From: Claire Booth
Sent: 05 September 2012 12:57
To: Jane Tucker
Subject: FW: Consultation on planning application 3/2012/0612 land opposite 3 Elker Mews, Billington

From: Hornby, Mark [mailto:Mark.Hornby@lancashire.gov.uk]
Sent: 05 September 2012 12:55
To: Claire Booth
Subject: FW: Consultation on planning application 3/2012/0612 land opposite 3 Elker Mews, Billington

SITE PLAN

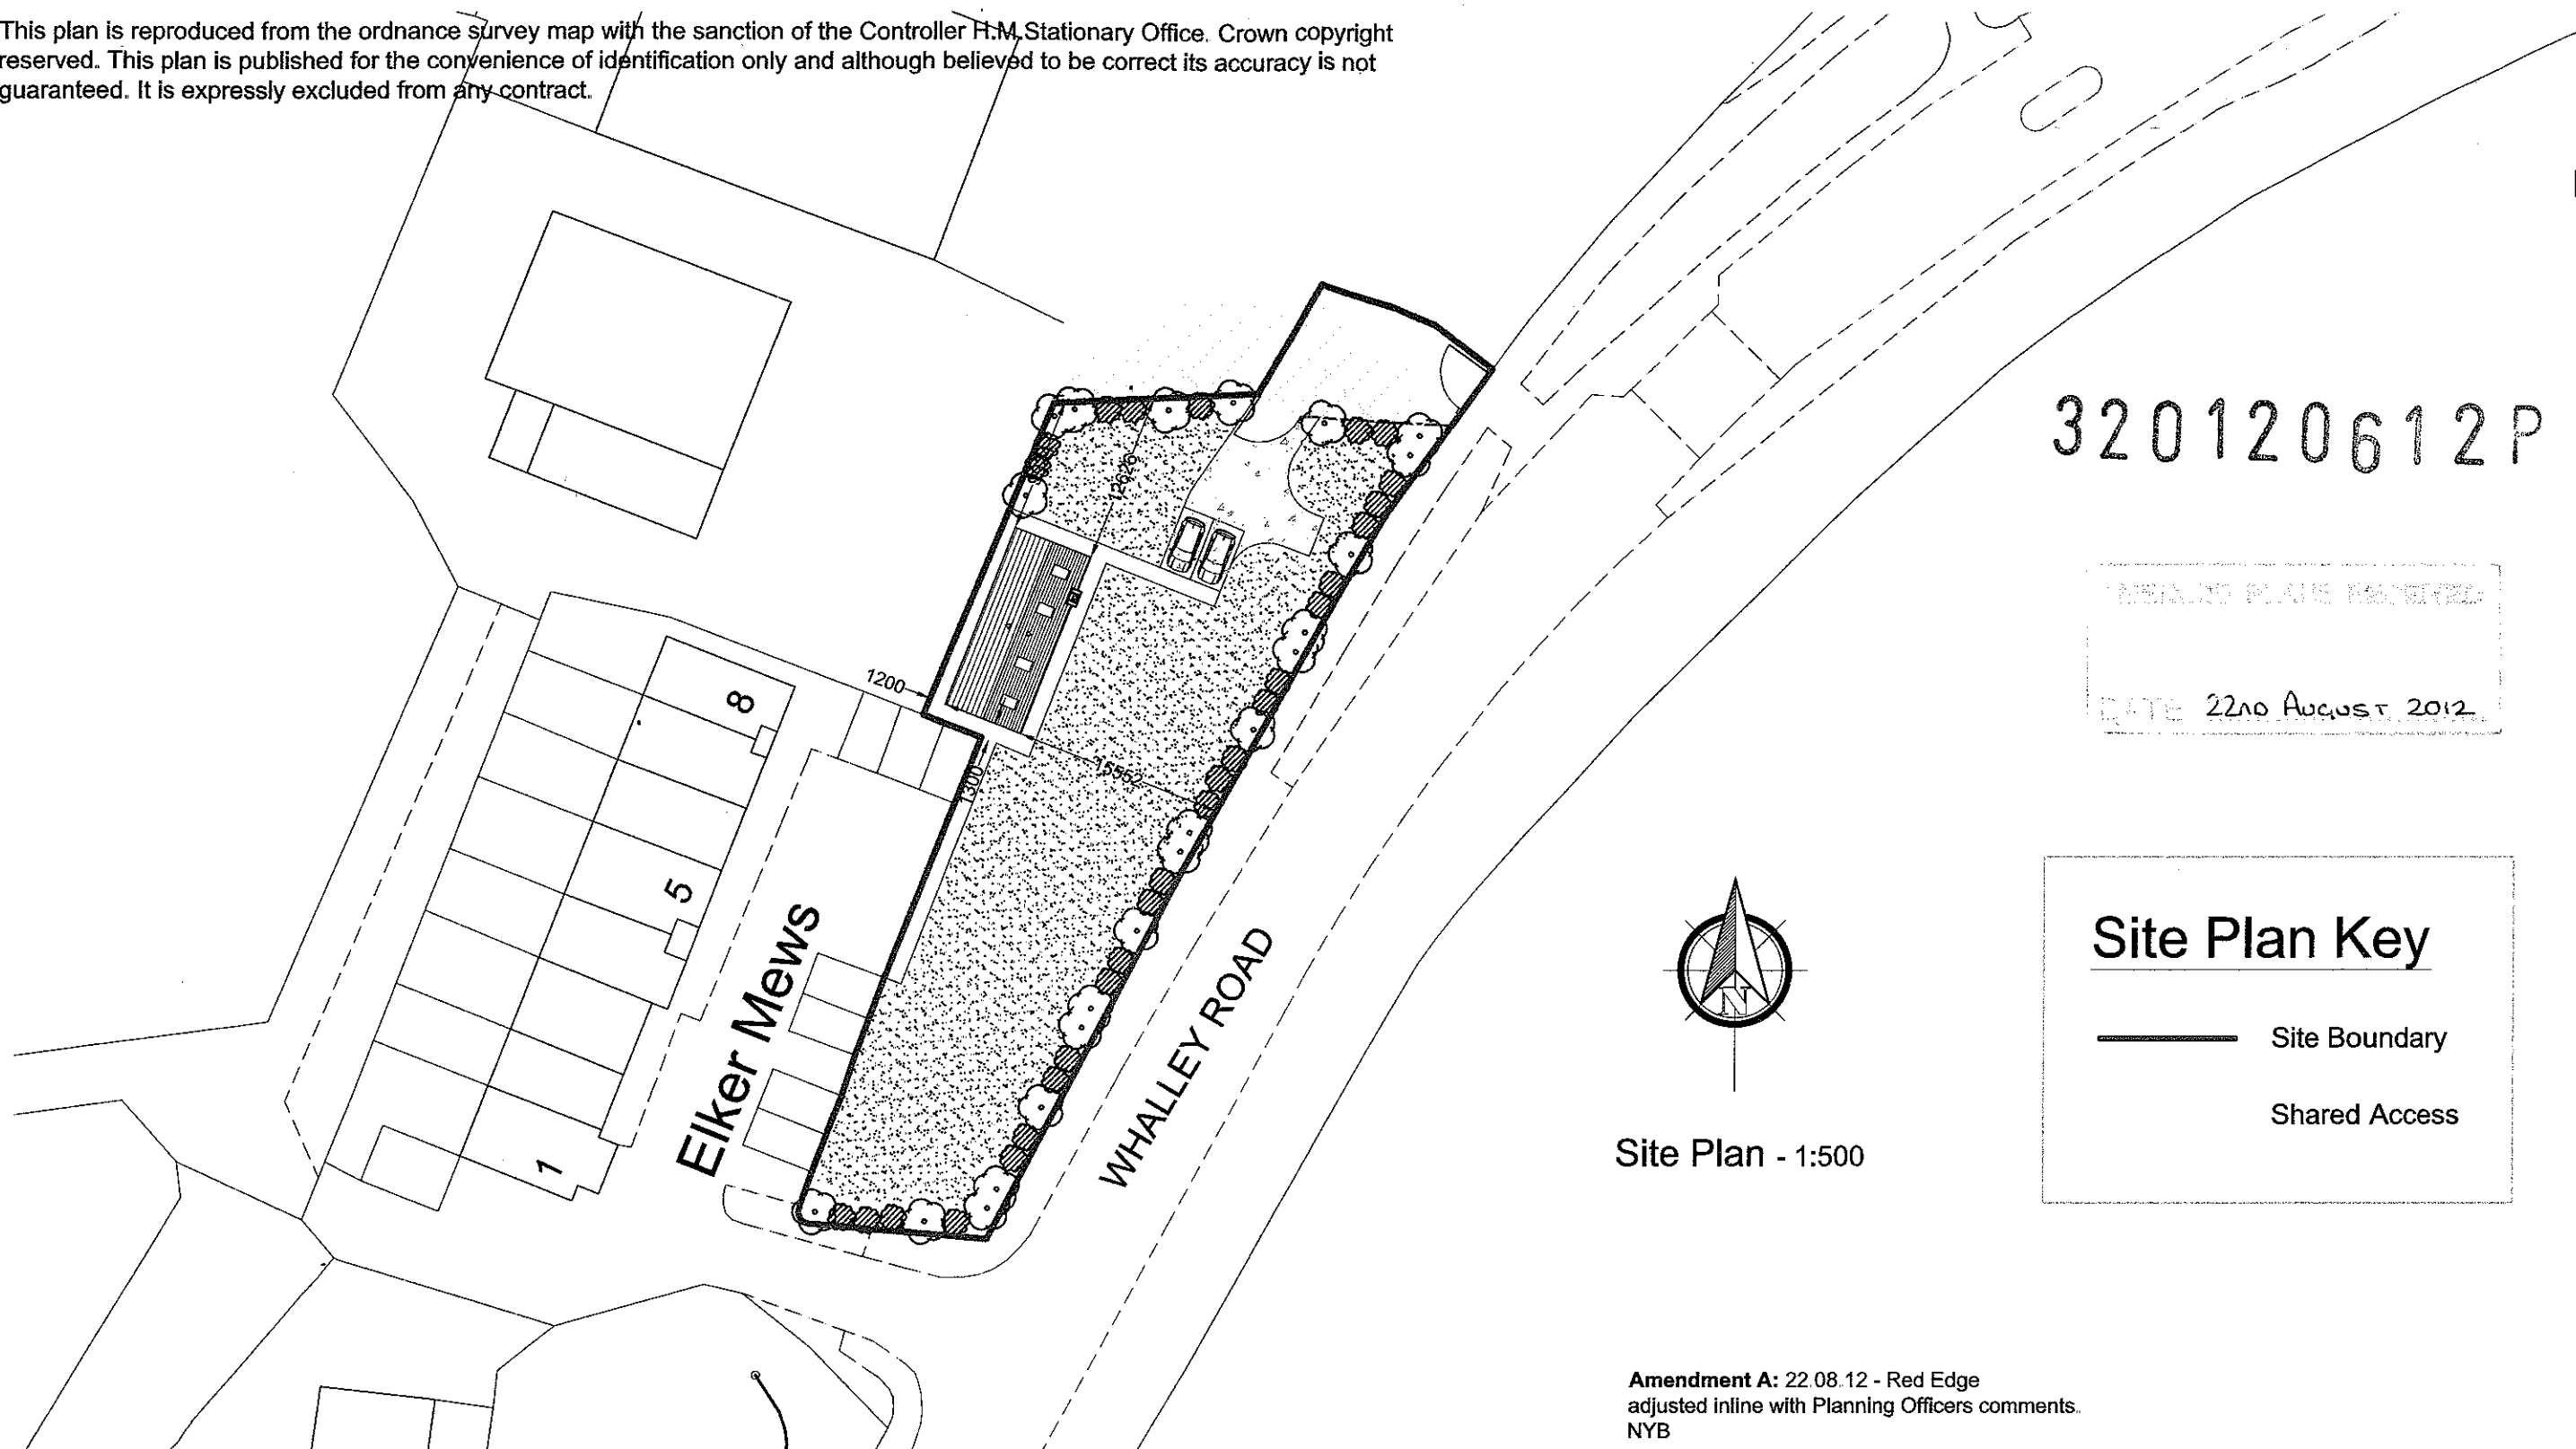
The proposed access to the development is via the existing track to the north of the site, which although gated has sufficient room for vehicles to stop clear of the carriageway of Whalley Road when entering or leaving the site. There is good visibility in both directions along Whalley Road at this point. The plans show adequate parking and turning space for two vehicles within the plot.

I therefore have no objection to this proposal.
